# ridge1 street review2.pdf Markup Summary

STM LAT "F" PROFILE

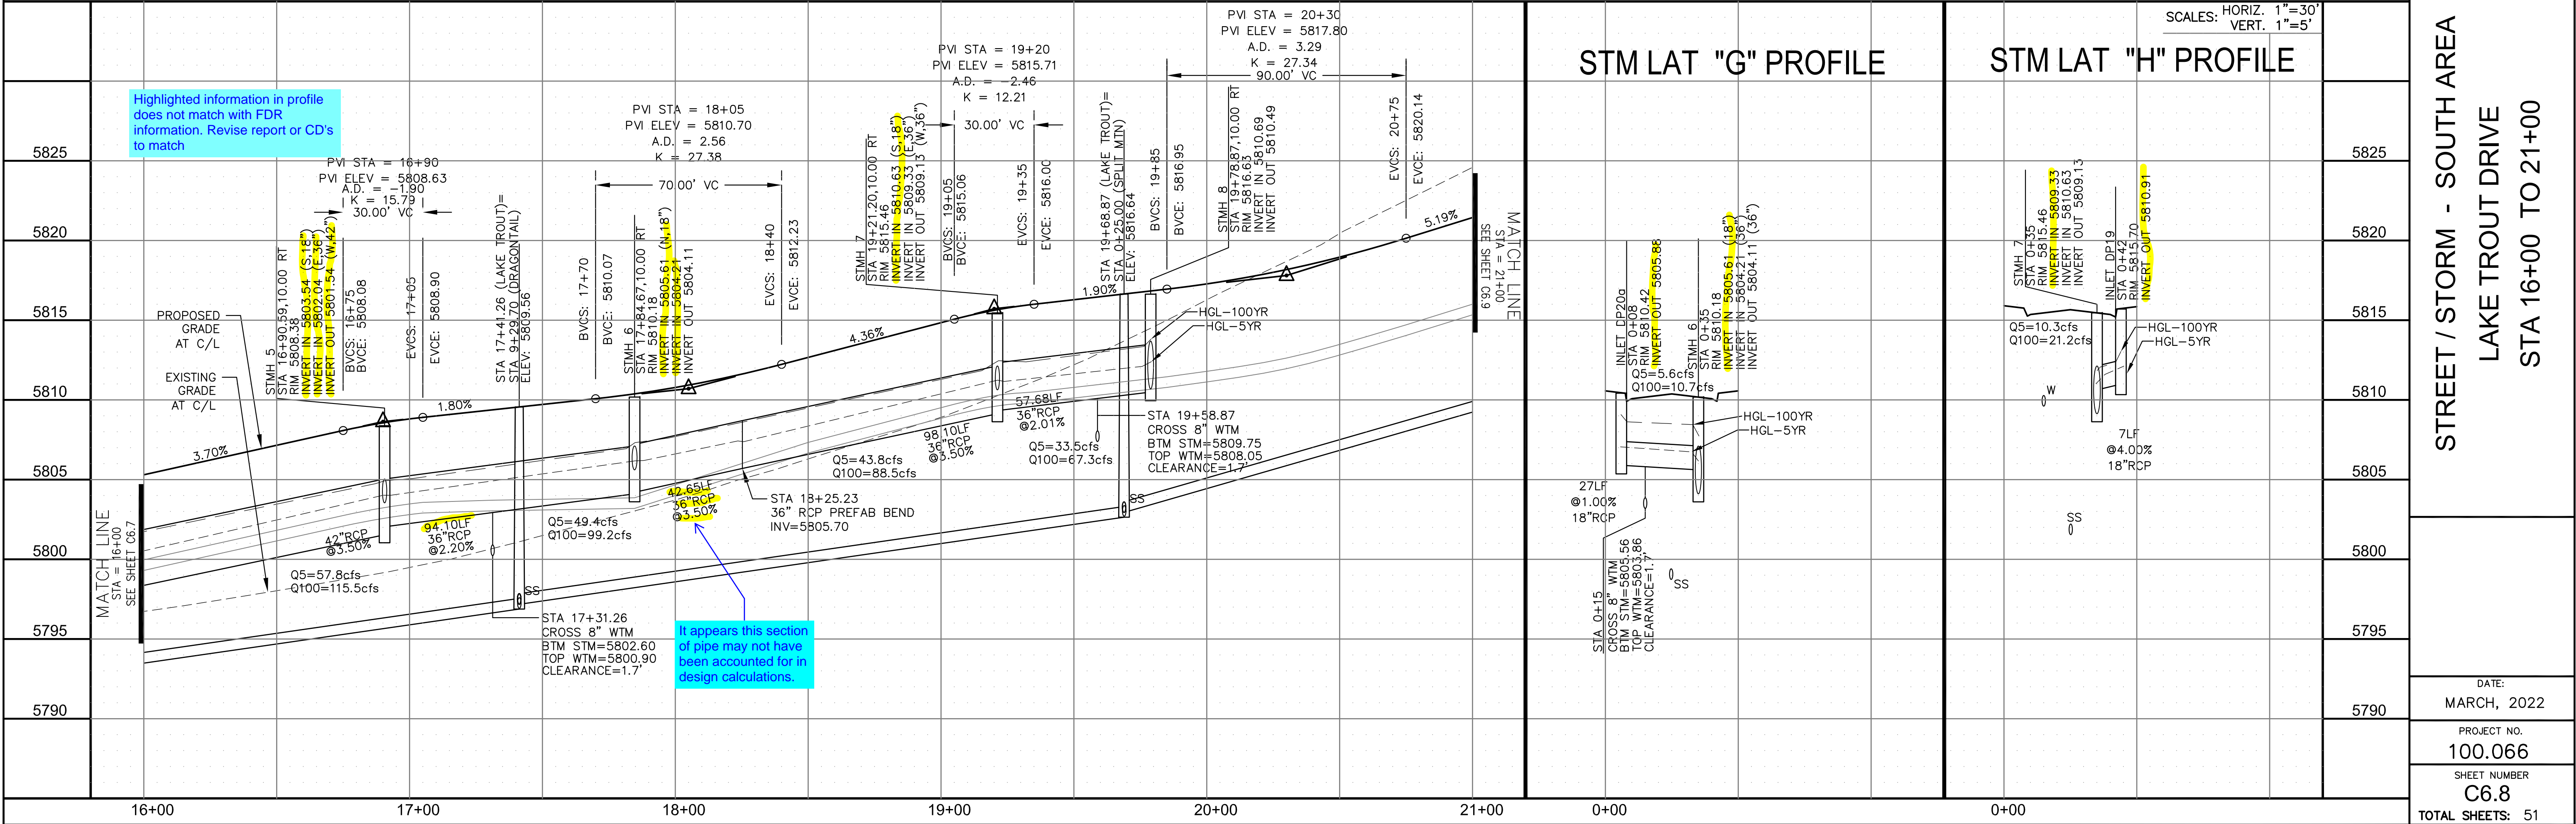
Highlighted information in profile does not match with FDR information. Revise report or CD's to match

MODEL IN FDR UPDATED

RAVEN RIDGE TERRACE

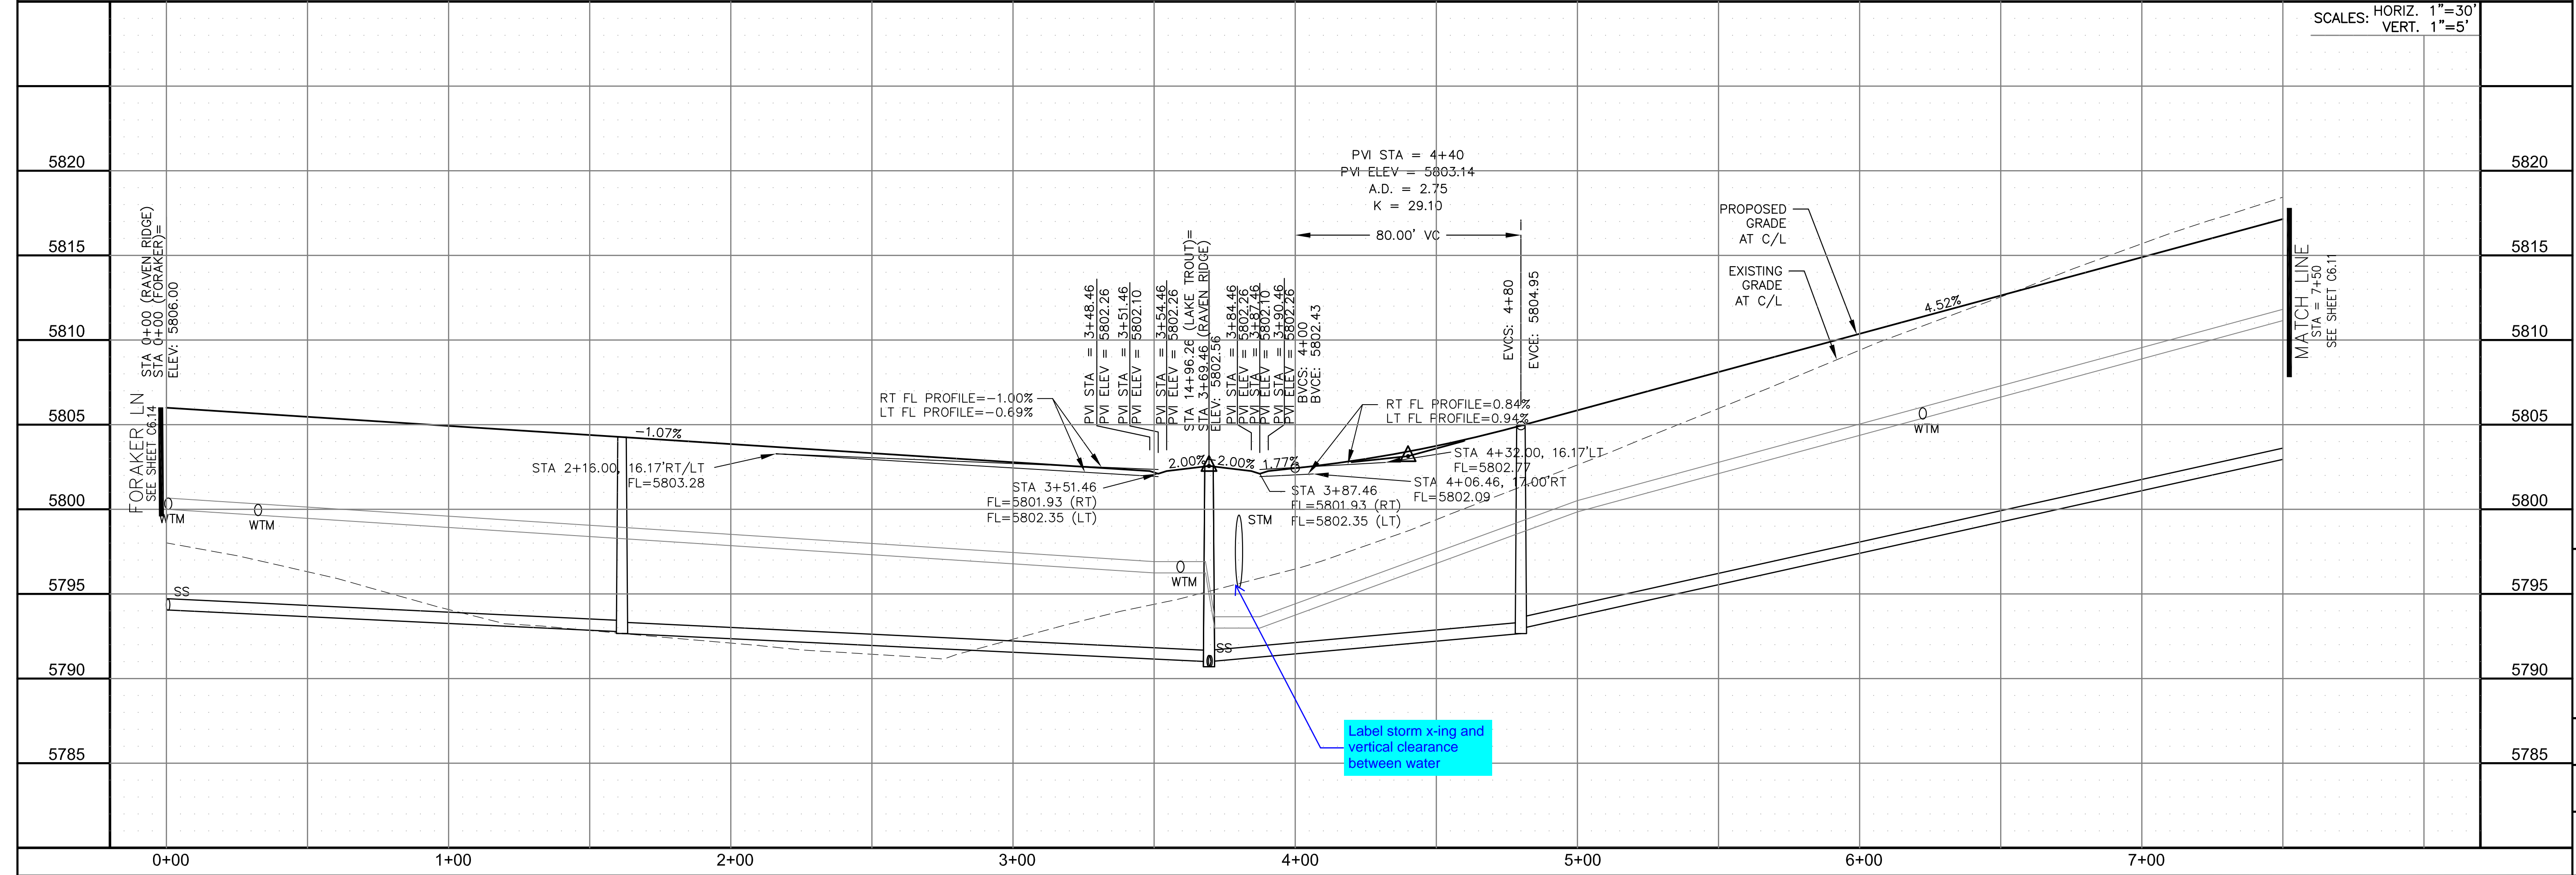
Label storm x-ing and vertical clearance between water

LABELED

STM LAT "K" PROFILE

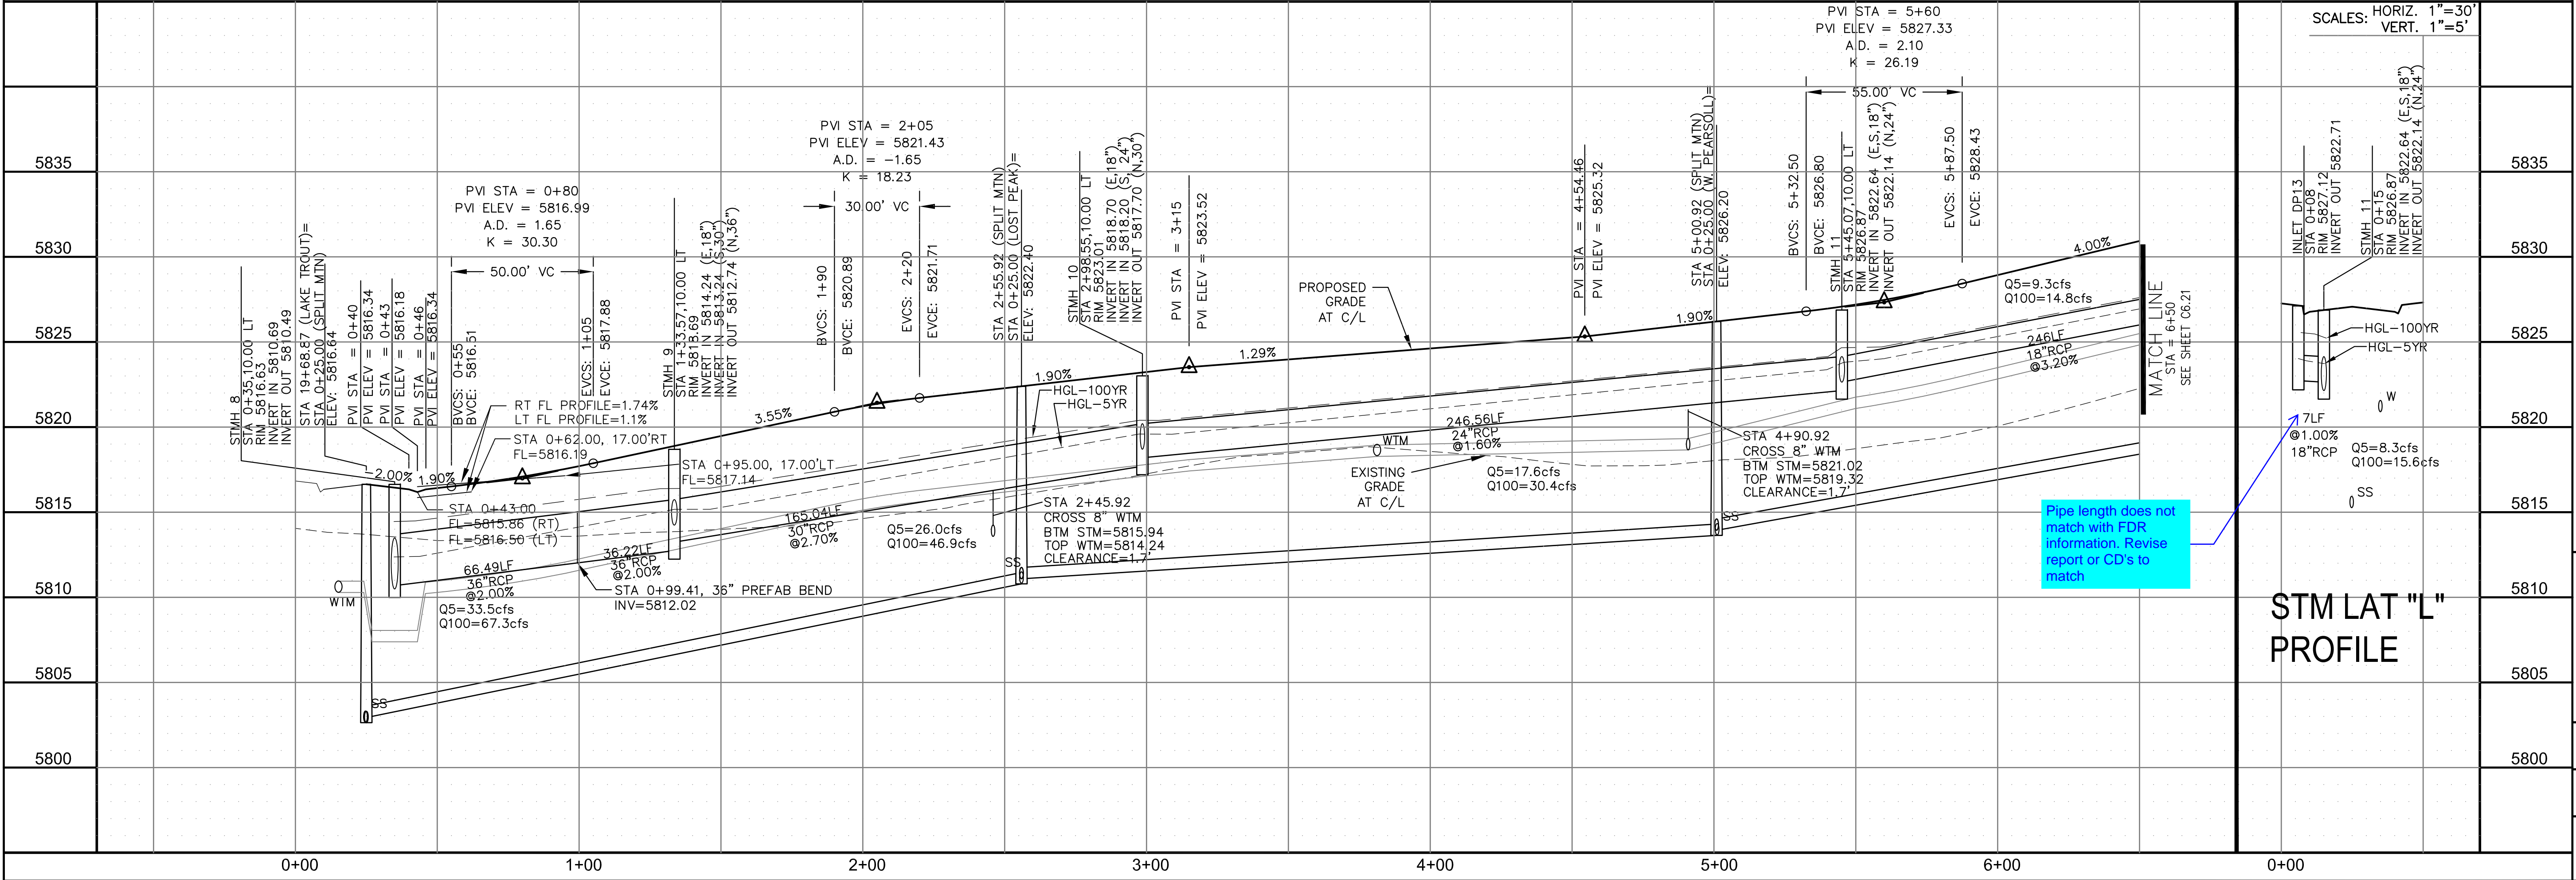
Pipe length does not match with FDR information.  
 Revise report or CD's to match

MODEL UPDATED

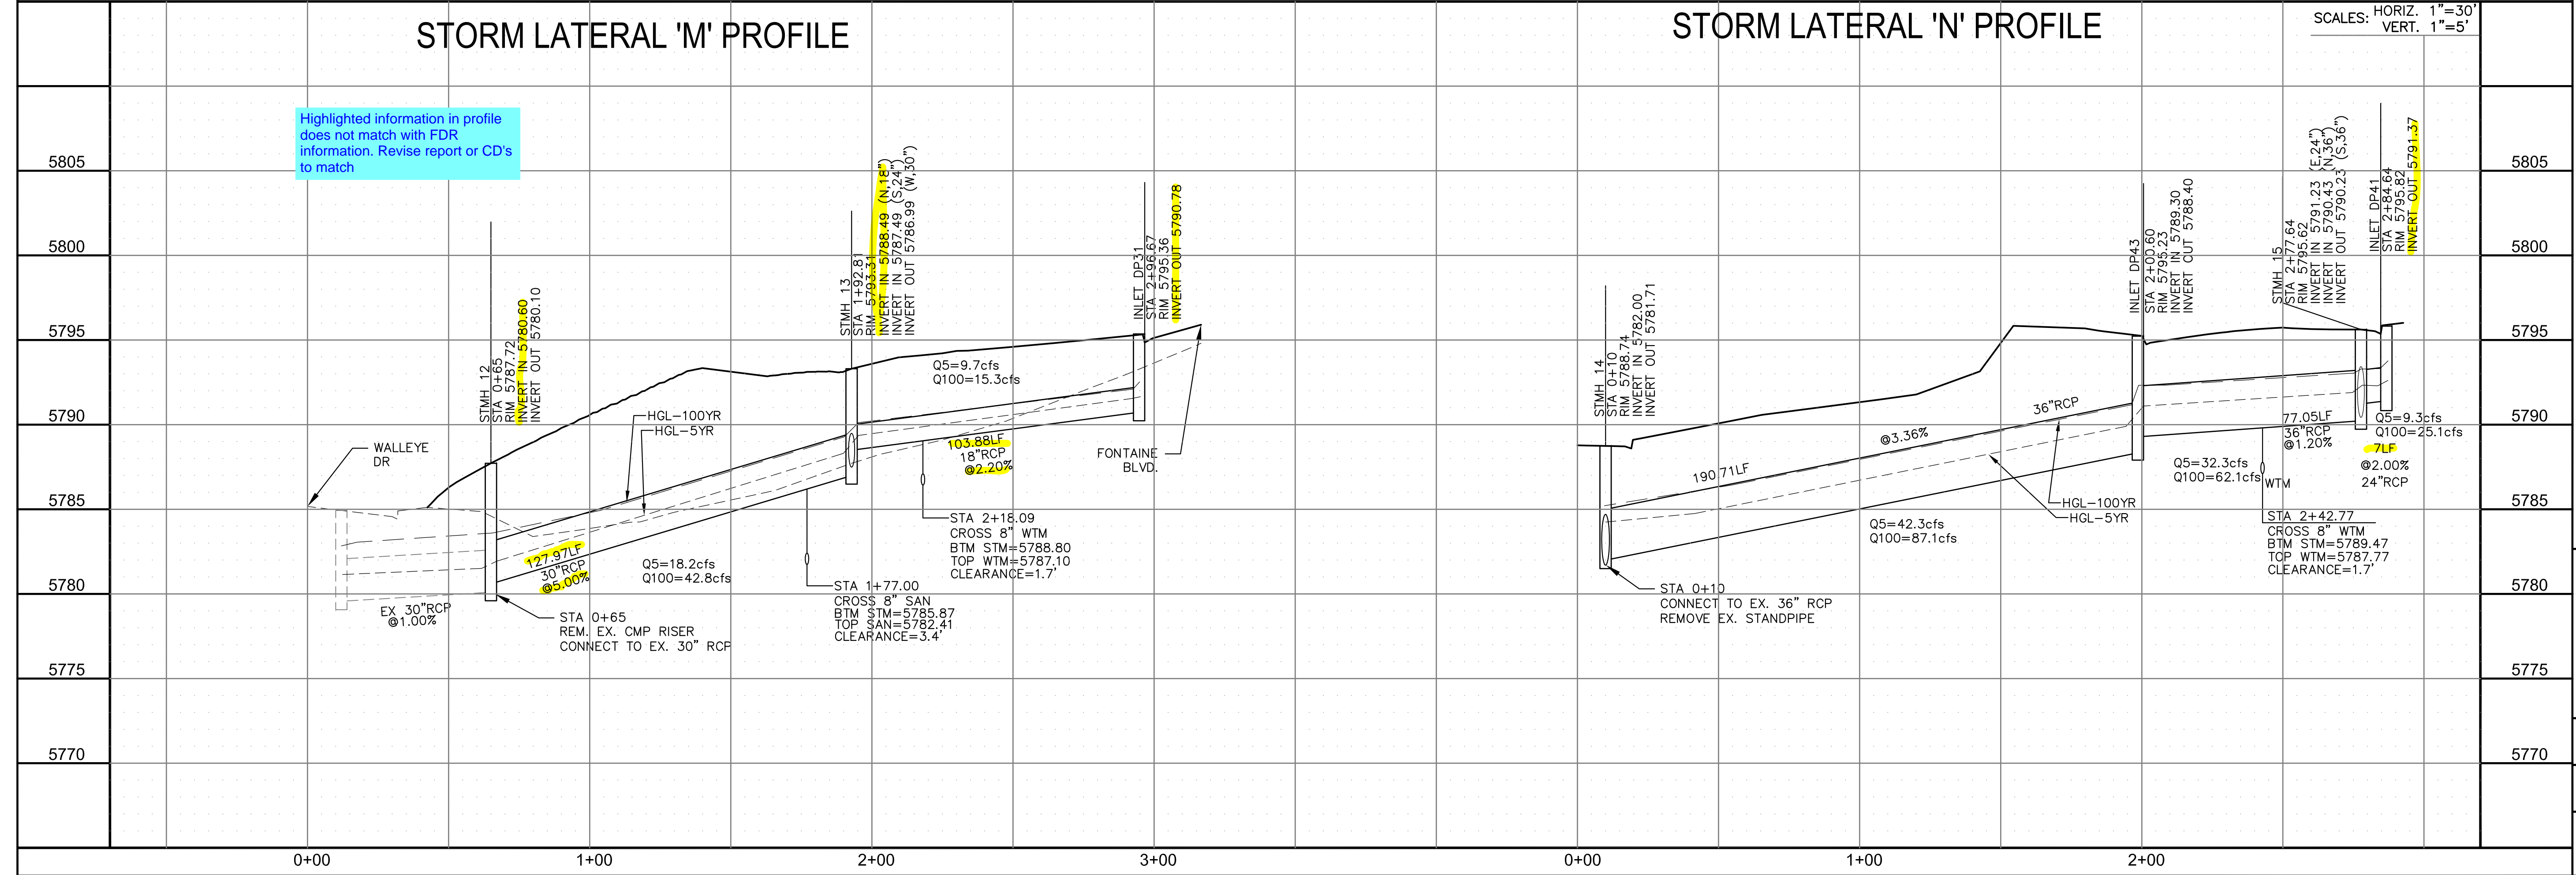
Highlighted information in profile does not match with FDR information. Revise report or CD's to match

MODEL  
UPDATED

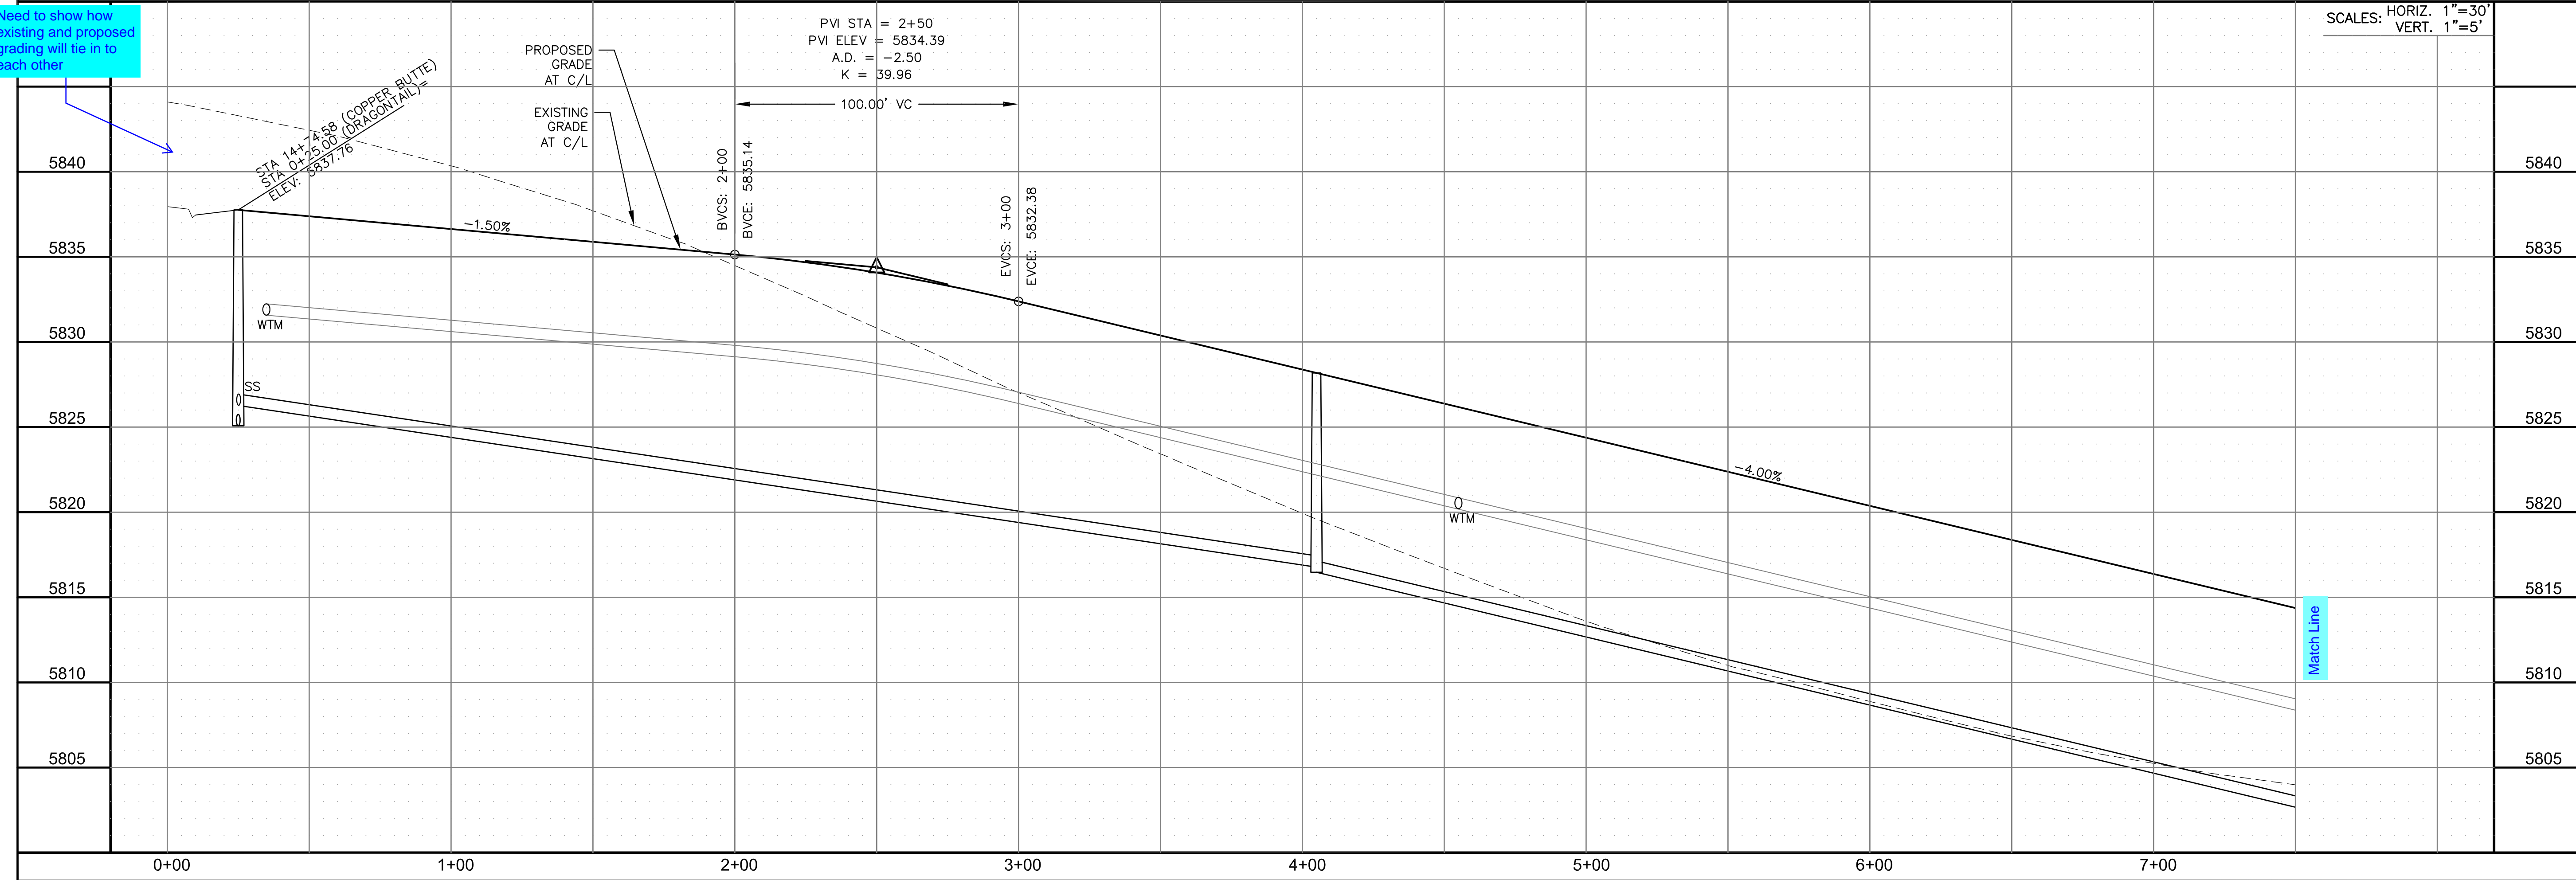
Need to show how existing and proposed grading will tie in to each other

GRADING EXTENDS BEYOND PROFILE
